File No: NTH08/01328; CR2014/004342
Your Ref: SSD 6573

Main Road 545 - Ewingsdale Road – SSD 6573, Byron Shire Central Hospital, Ewingsdale.

1.1 Western Access – 1 Lane Roundabout

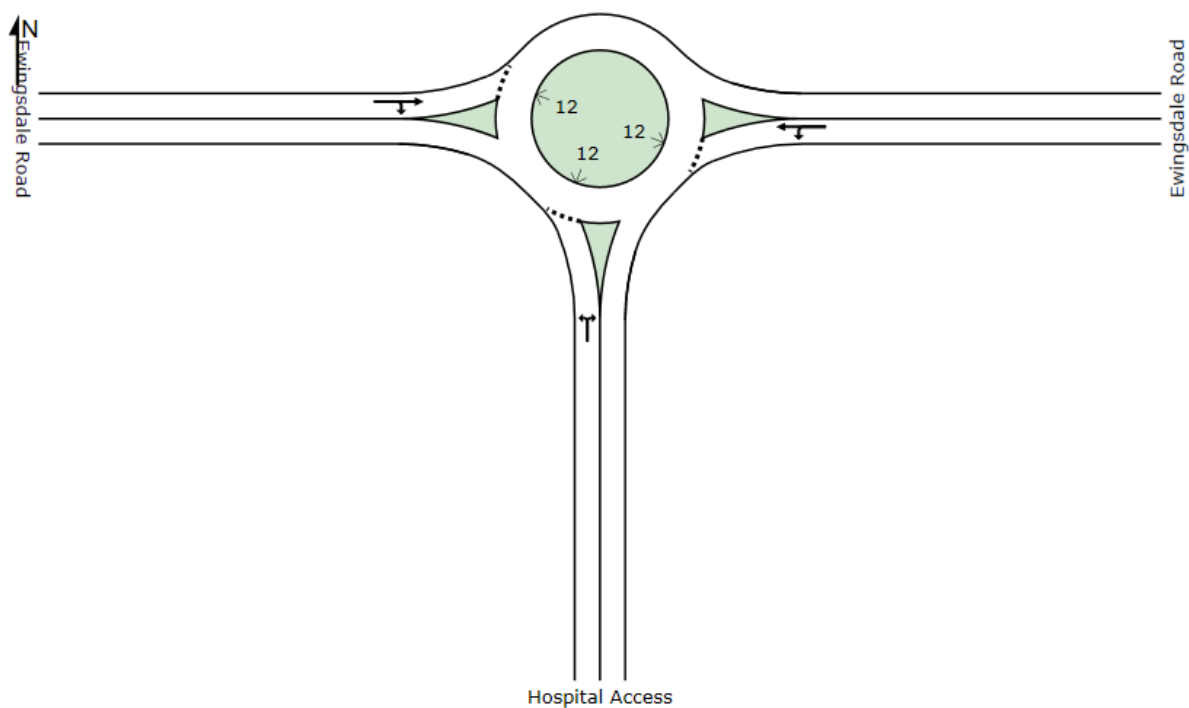
- From a strategic planning perspective the design of the roundabout needs to allow for a future upgrade of Ewingsdale Road to four lanes.
- Eastbound buses will require a pickup/set down area within the site to reduce the need for pedestrians to cross Ewingsdale Road.
- The combination of this development and the planning proposal for a Seniors Living development on the land immediately east and west of the hospital site has the potential to cause traffic disruption on Ewingsdale Road.
